**Consultation Response from KC,
Lead Local Flood Authority**

2025/90708 Land at, Merchant Fields Farm, off Hunsworth Lane, Cleckheaton

Discharge of details reserved by conditions 3 (Construction (Environmental) Management Plan), 6 (Temporary surface water management details), 8 (Proposed internal adoptable roads), 9 (Permanent site entrance details), 16 (Surface water attenuation details), 17 (Details of Swale/ditch management), 19 (Phase II Site Investigation details), 20 (Remediation Strategy), 25 (Noise Impact Assessment), 30 (Arboricultural Method Statement/ Tree Protection Plan), 34 (Biodiversity Gain Plan) of permission 2024/91260 for Variation of conditions 2 (plans and specifications) and 35 (removal of permitted development rights) on previous permission 2021/92801 for erection of 291 dwellings with associated works and access from Hunsworth Lane and Kilroyd Drive – revisions to house types, unit size mix and layout

Responding Officer: Paul Farndale

HYDROBRAKE DETAIL
NOT TO SCALE

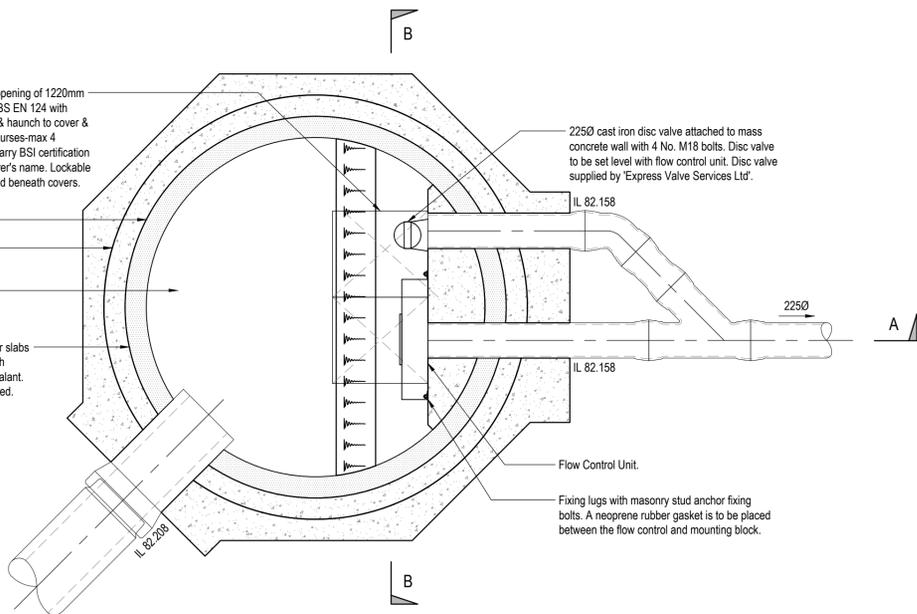
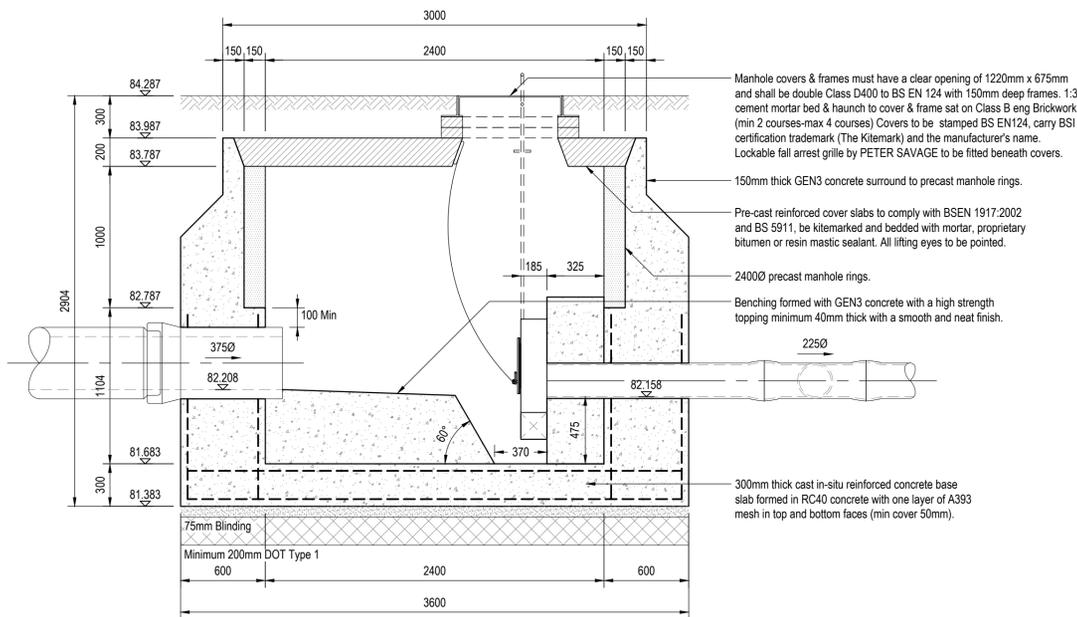
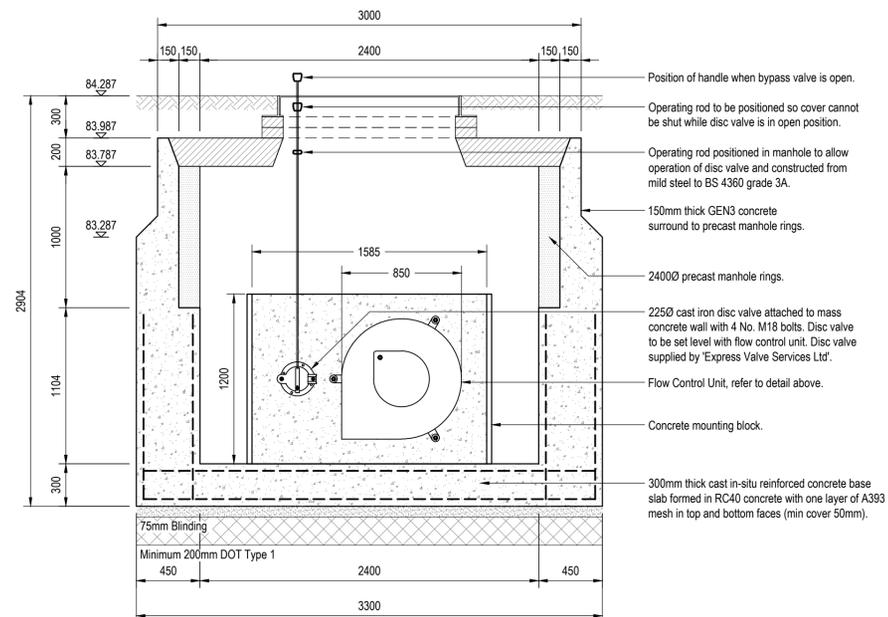
A carlow tank is listed on one drawing and crate storage on another.

A final tank and pond design including plan and cross sections are required with volume identification. Materials and liners should be clearly indicated. Structural calcs for any elevated pond will need to be assessed and signed off by a competent person. A cross section of pond to outfall and beck is also needed.

The pond should also show 1 in 1, 1 in 30, 1 in 100 and 1 in 100 + climate change critical water levels and invert level and any freeboard above the 1 in 100 + climate change level. Details of inlets and outlets have not been submitted

Plans and cross section of the outfall to beck and any baffle/erosion protection and flap valve should be submitted. The flap valve should be 150mm minimum above the normal water line.

APPENDIX 1

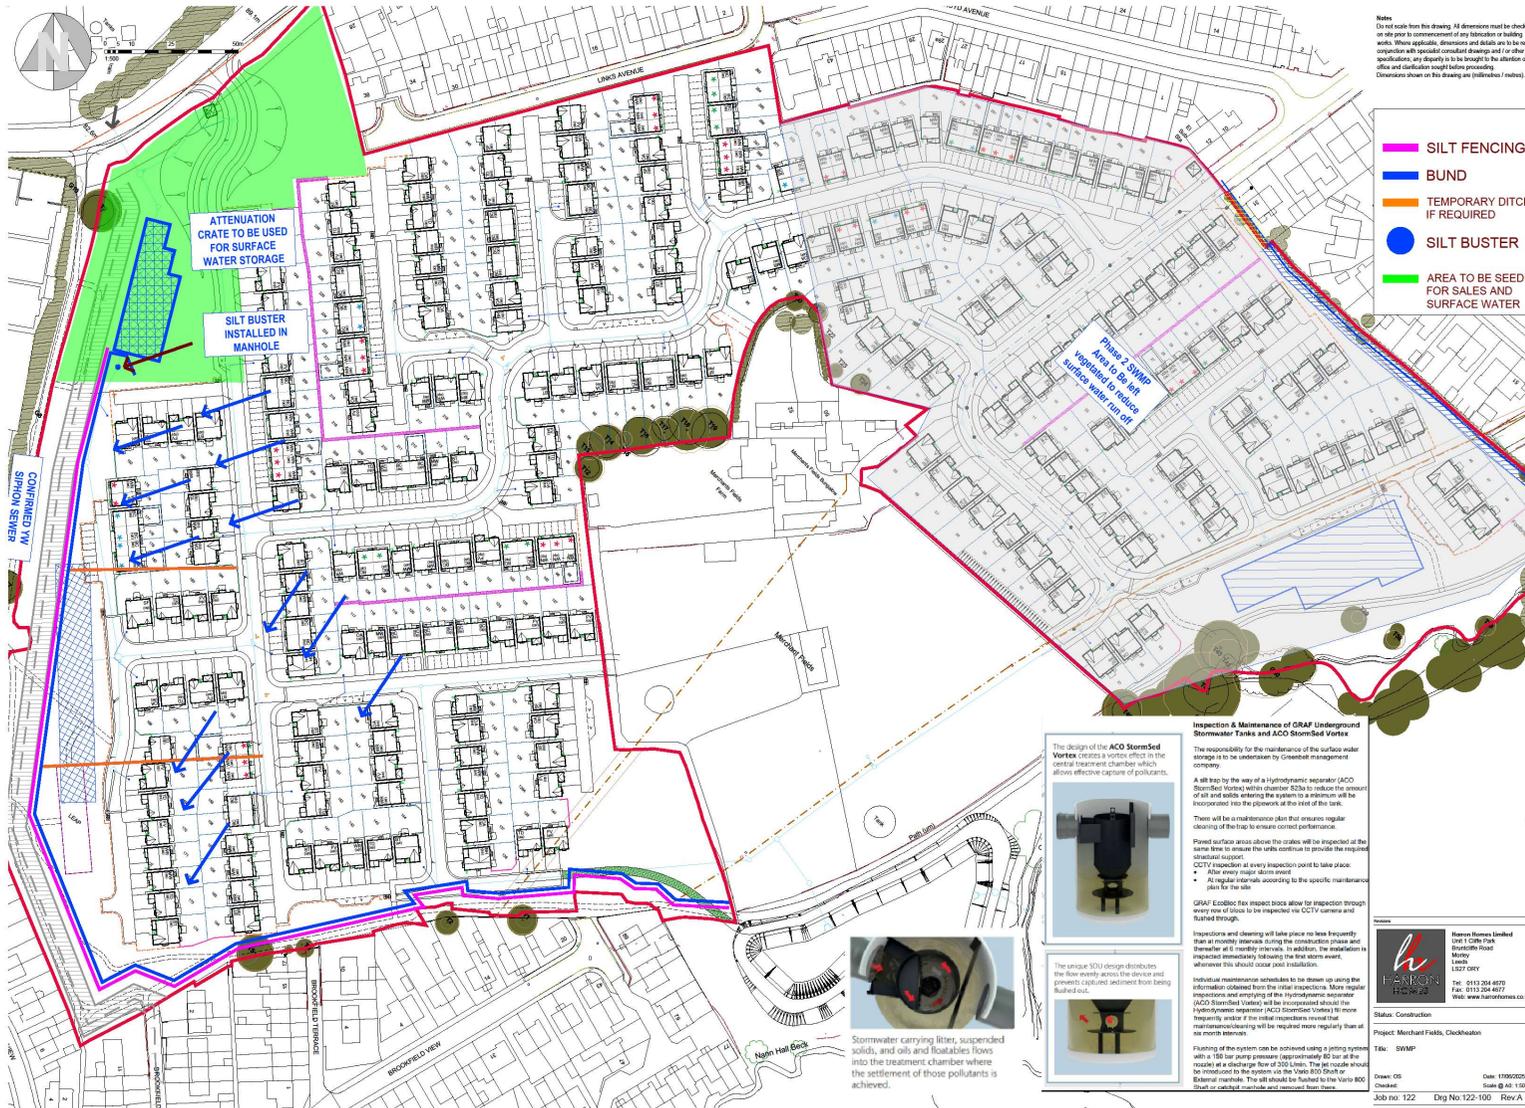
A narrative needs to accompany any drawings to demonstrate a risk assessment of flooding and pollution has taken place and a bespoke method to reduce risk to acceptable levels via an itinerary and schedule of task linked to different phases of the project.

Back up plans are required should initial measures be exceeded, such as tankering and flocculation.

The temporary drainage information shows a tank instead of the intended pond which is incorrect. Site soil strip areas must be identified prior to drainage being installed. It is recommended not to completely strip the site if practicable and therefore untreated water landing on these areas can be passed on.

Any bund system used will have a low spot. For a site like this a 1 in 2 year/ 1 in 5 year 6 hour storm should be held on site depending on the estimated build time. This should be clearly shown on plans with calculations.
